**RE: Lot 10 Block 3 Unit 22, S.A.D. 228
Volcano Cliffs Subdivision
8001 Camino Alderete NW
Grading and Drainage Plan
Engineers Stamp Date 5/19/2021
Rev; 2/1/2022 (D10D003R10)**

Based upon the information provided in your submittal received 2/17/2022, this plan cannot be approved for Certificate of Occupancy until the following comments are addressed.

GRADING AND DRAINAGE PLAN

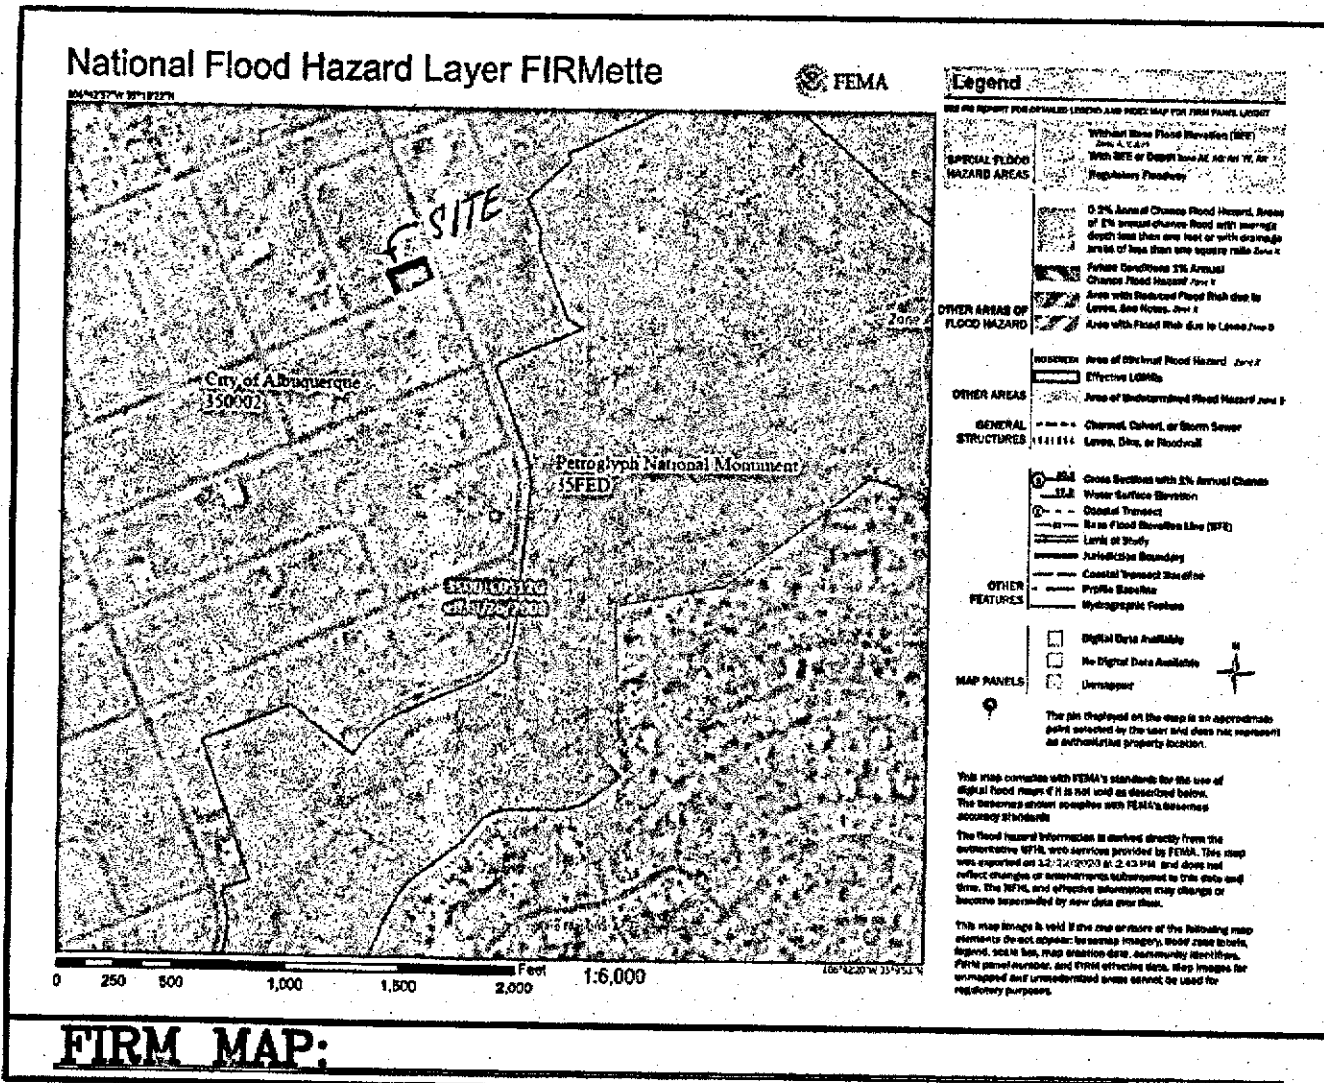
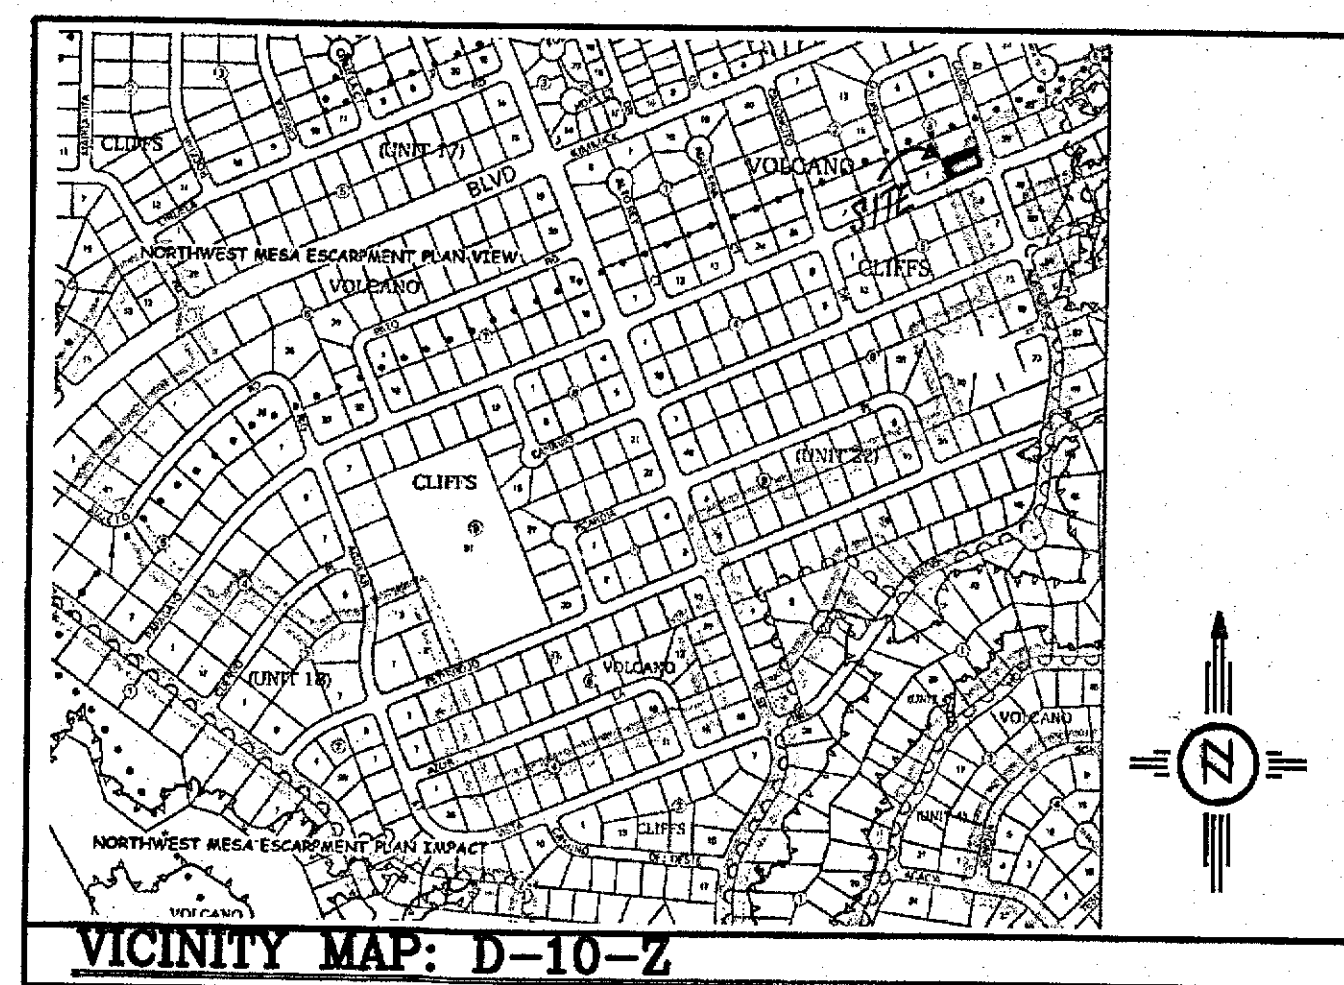
- All ponds need to be in place.
